Recommendation Report for Planning Permission for Works or Extension to a Dwelling

REF NO: Y/121/20/HH

LOCATION: 14 East Bank
North End Road
Yapton
BN18 0DJ

PROPOSAL: Installation of a dropped kerb

Proposed Block Plan - 1:500 @A1

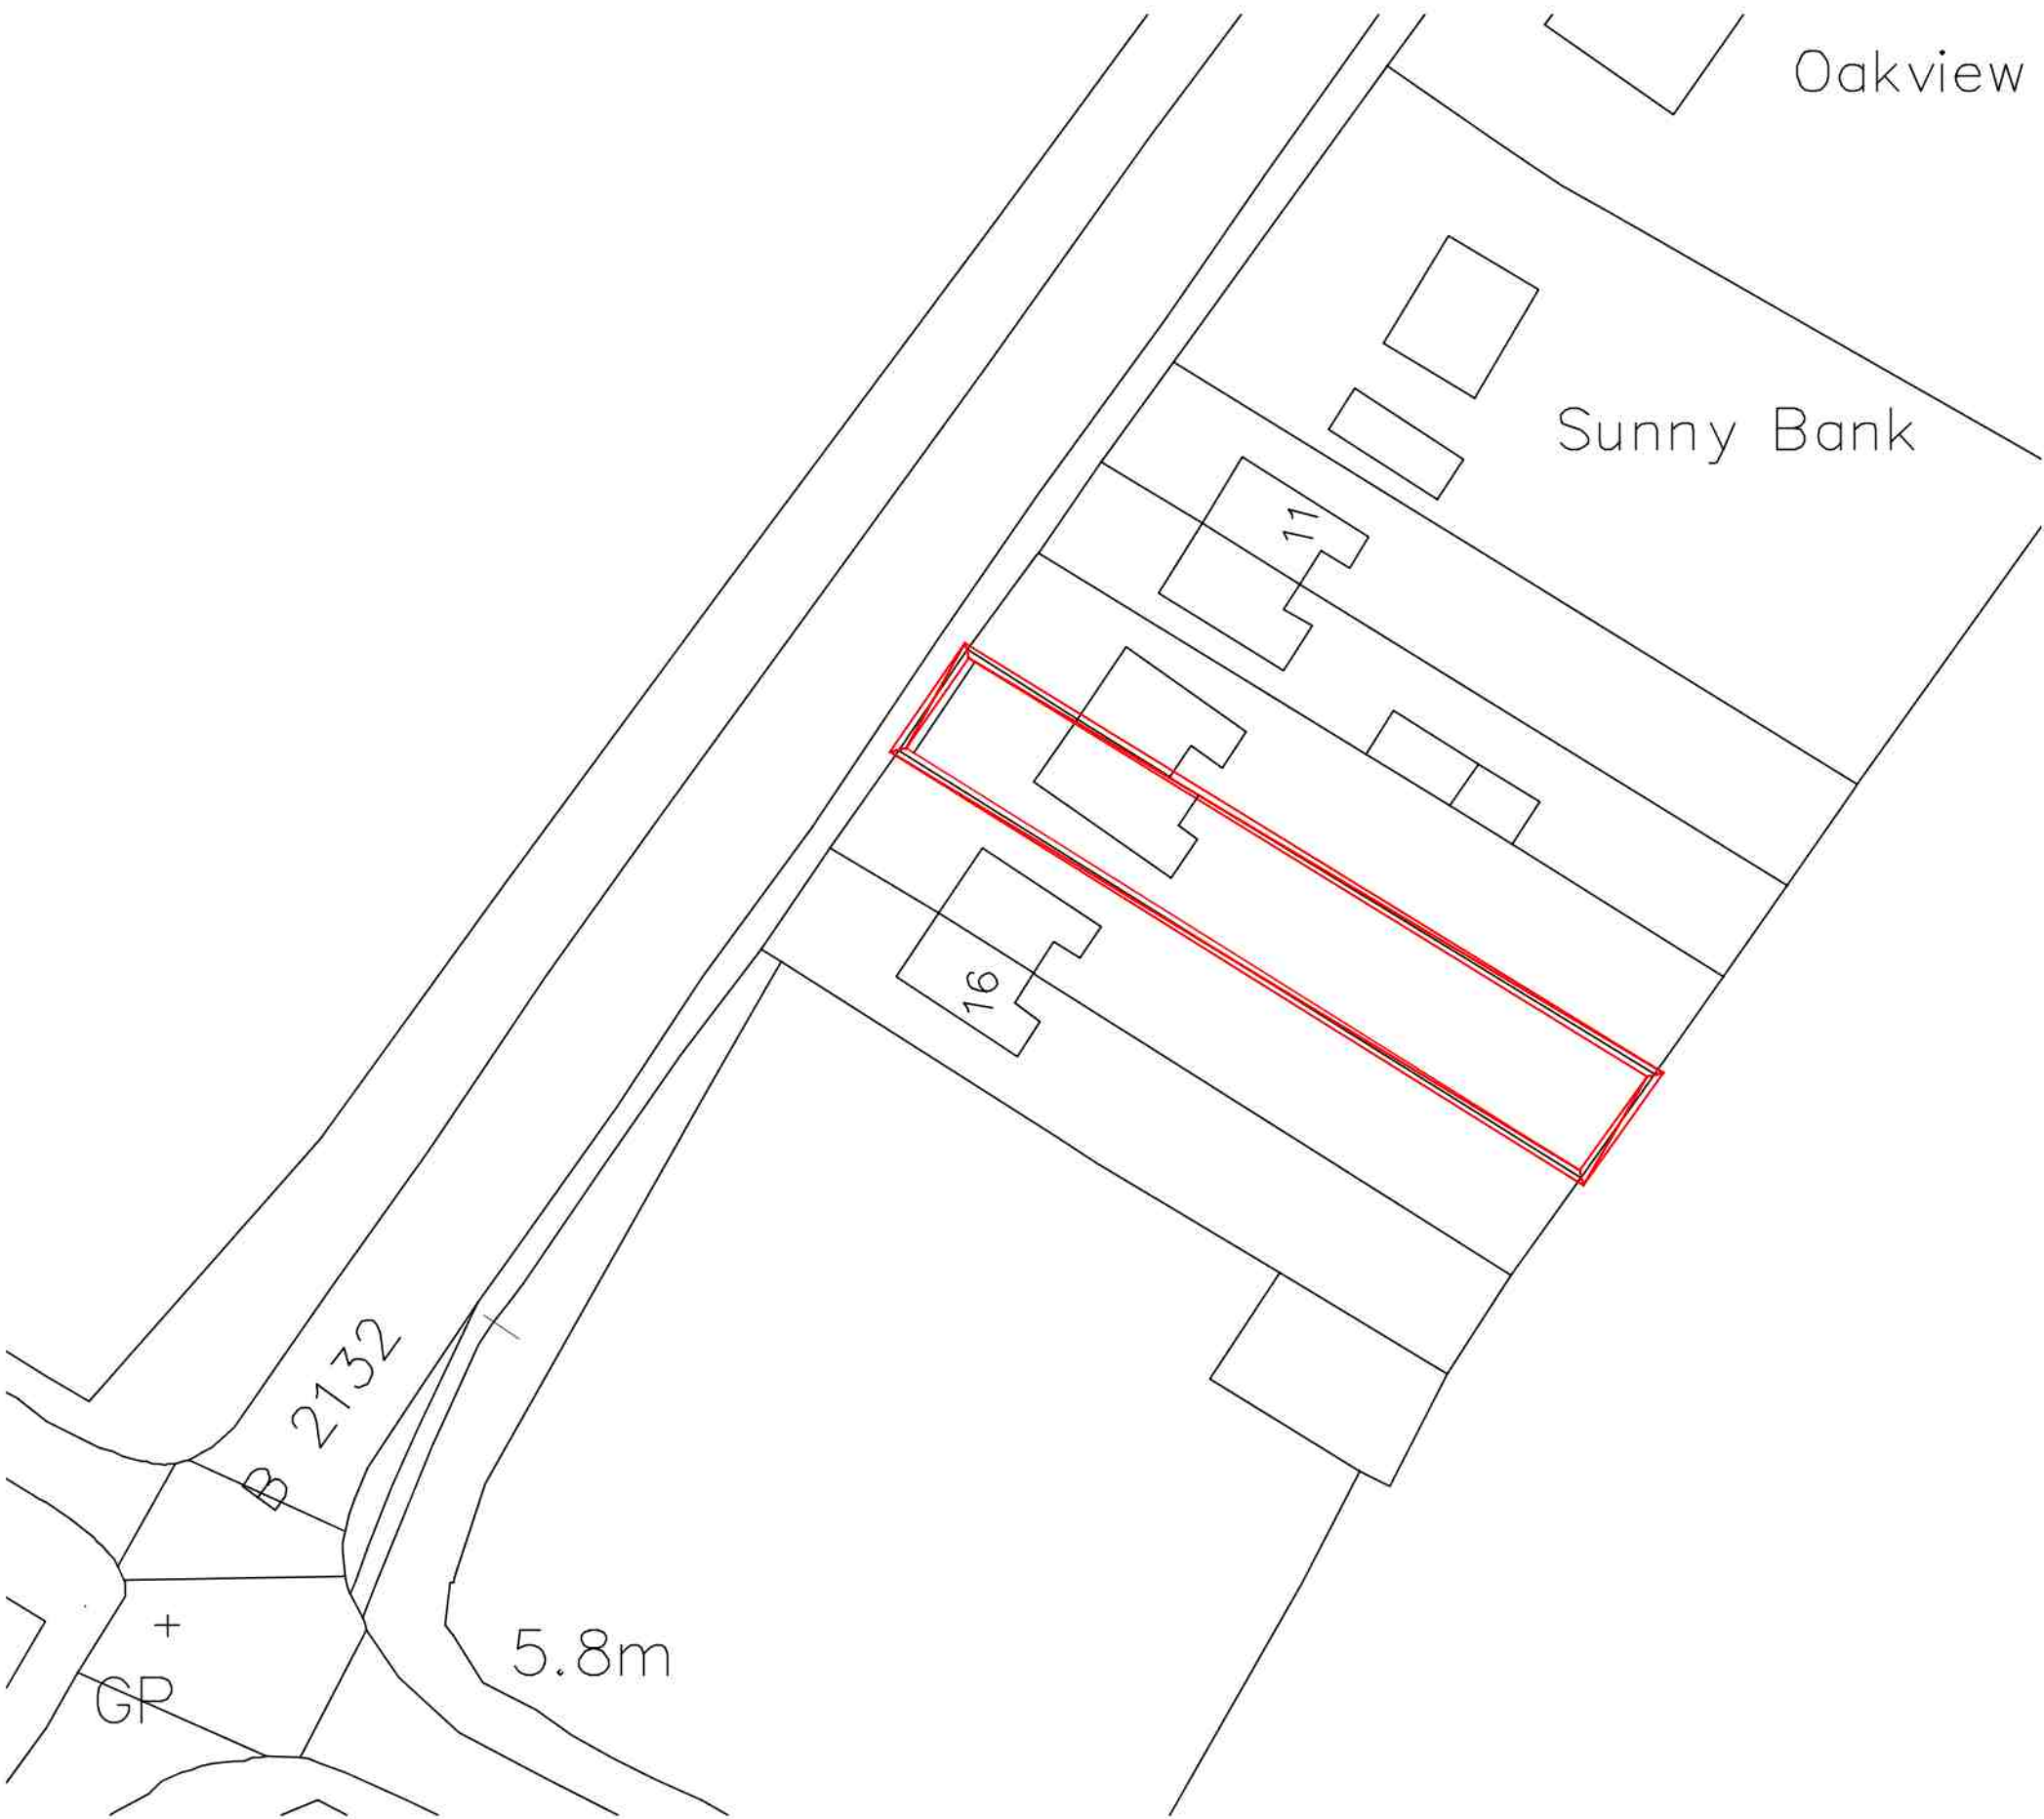
- Visibility splays crossing 3rd party land,
- The access is 6.42m.

The proposal requires additional information relating to visibility and the width of the access in line with WSCC consultation. As such a decision cannot be made with regards to the safety of the works upon the highway.

- 1 In the absence of adequate information demonstrating the full visibility extent and access width it can not be demonstrated that the proposal would not result in harm to highway safety contrary to policy TSP1 of the Arun Local Plan.
